PLANNING BOARD REPORT PORTLAND, MAINE

Jewish Community Center and Preschool/Daycare 1342 Congress Street

Conditional Use & Level III Site Plan Review

Project # 2015-058

EXISTING CONDITIONS AND DEMOLITION PLAN

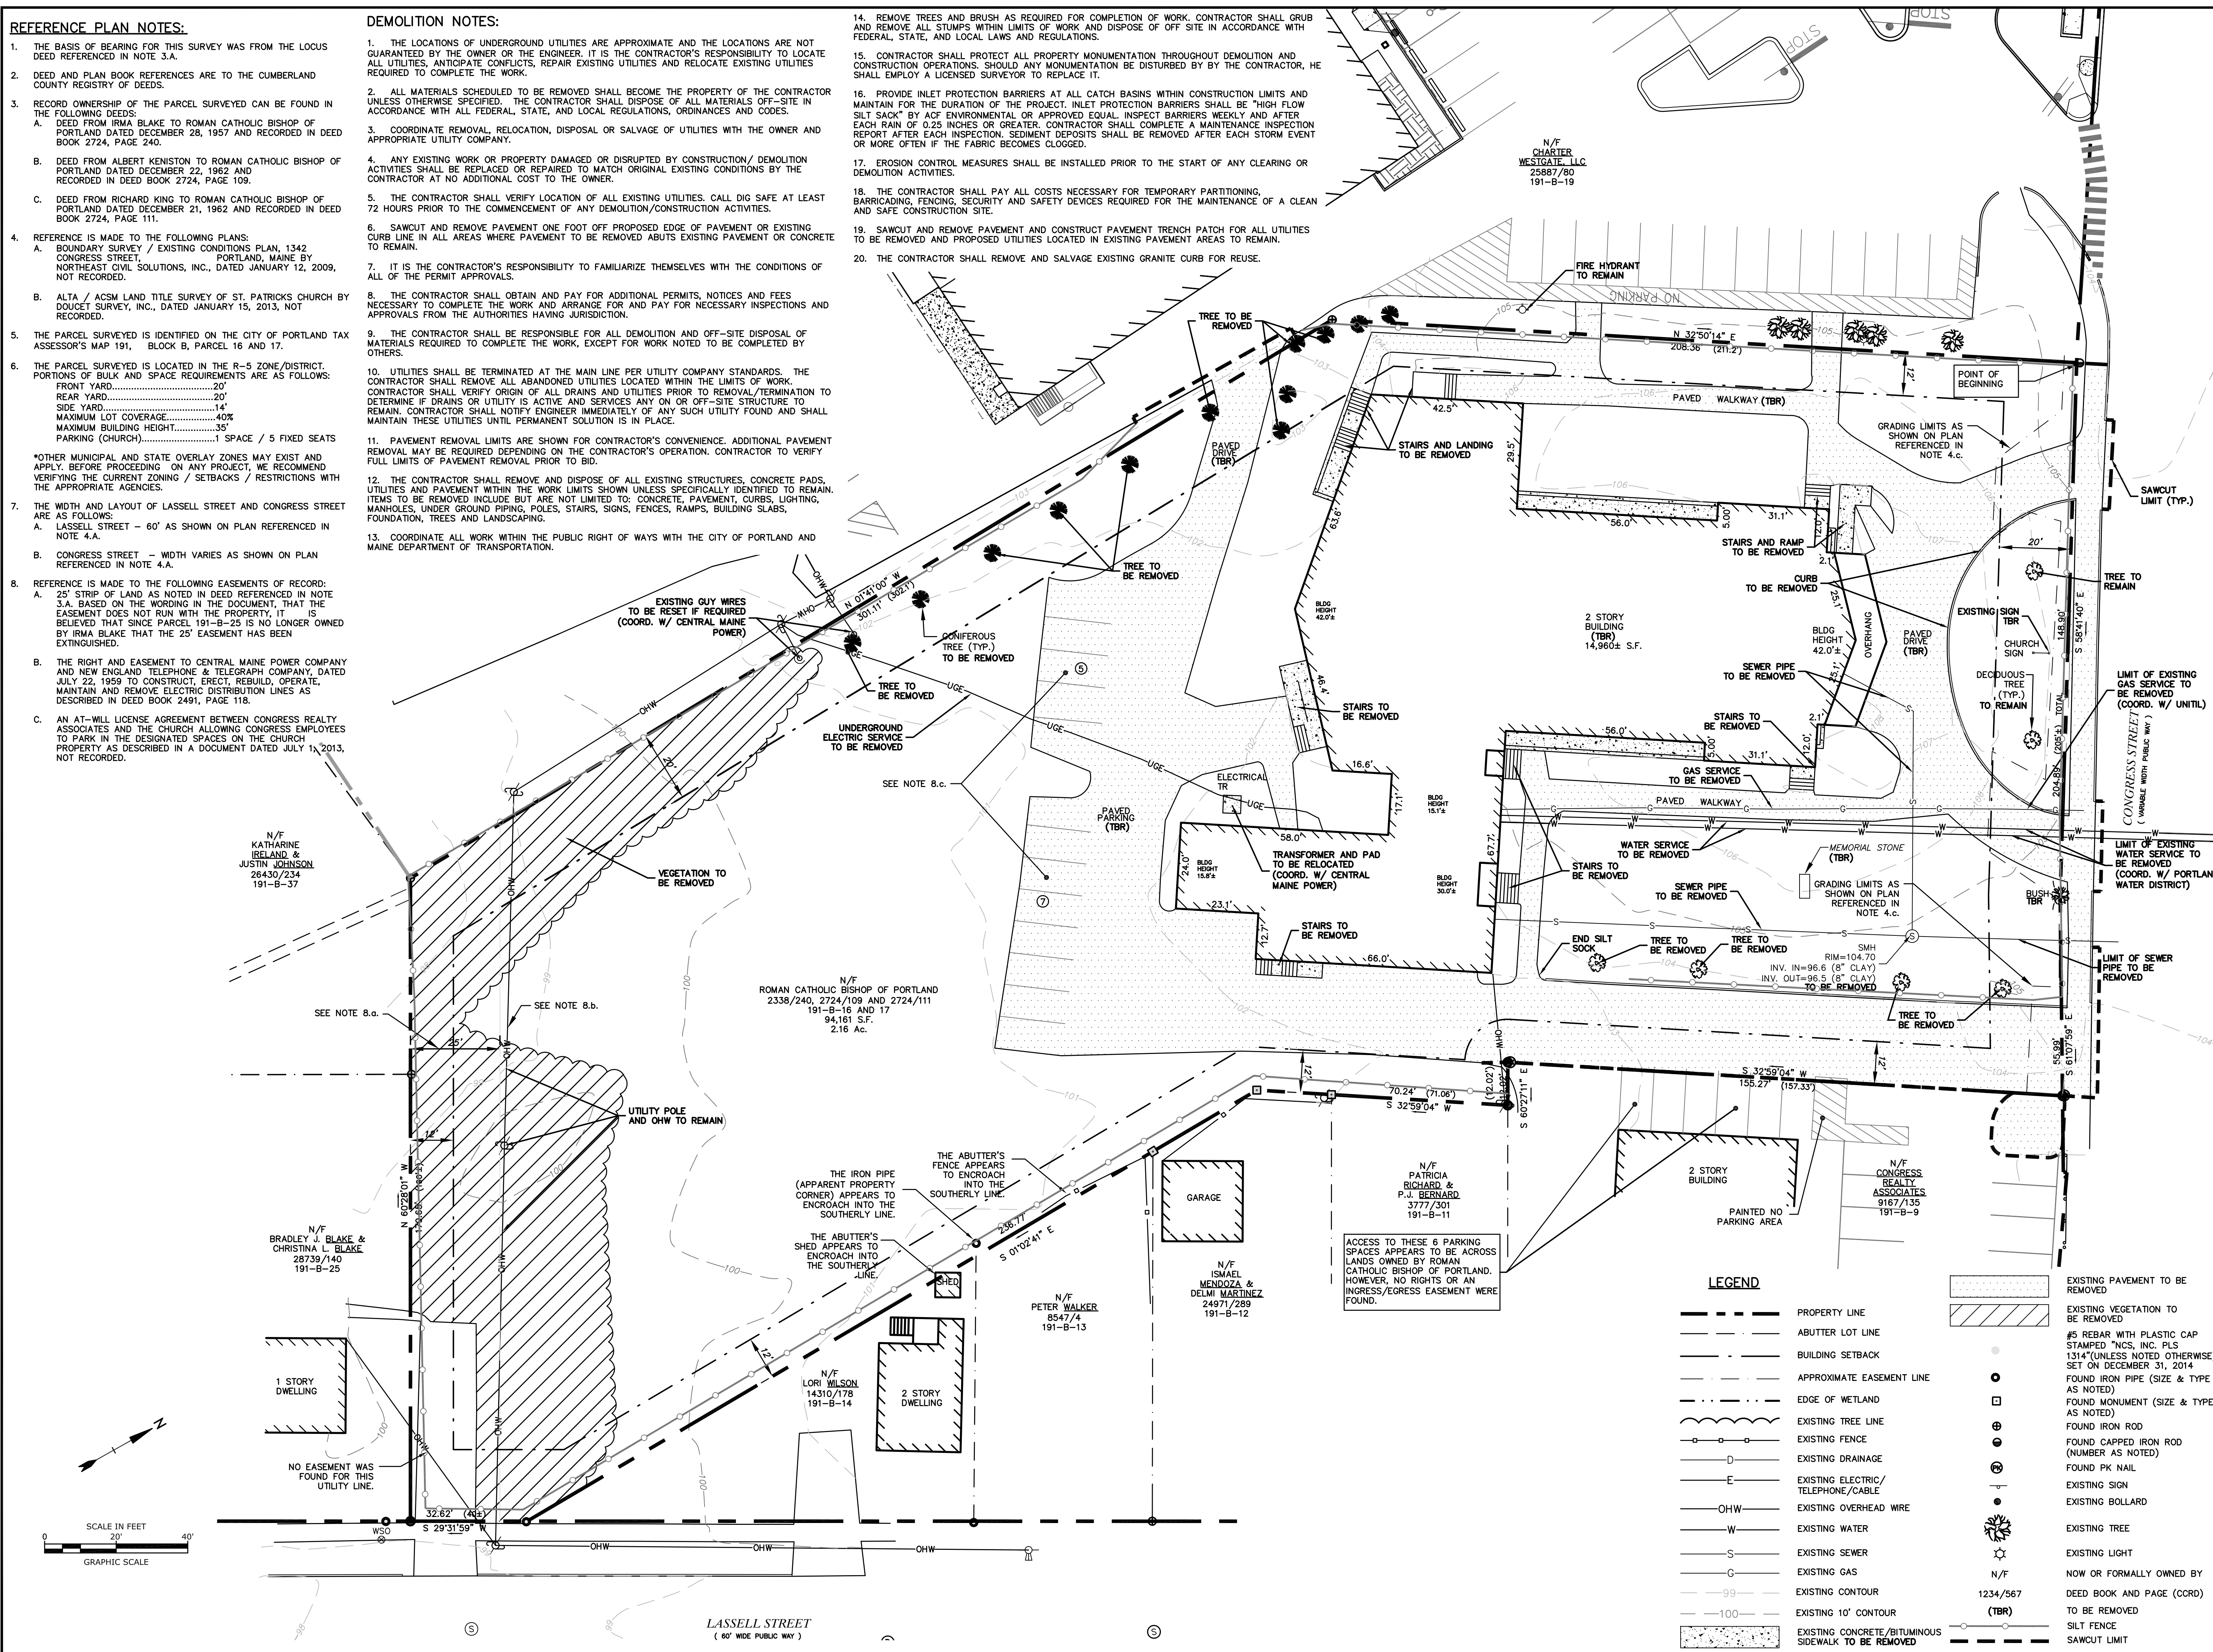
The Demolition Plan in Plan P4 shows the proposed removal of the 5 trees alongside the drive by the dental offices, and a considerable area of vegetation around the back of the site is also removed including near Lassall Street. A further 12 conifer trees are removed along the west boundary, which will become snow storage and parking area. The City Arborist expressed concern about the loss of the trees and also suggested the incorporation of a landscaped island at Congress Street (Attachment 5)
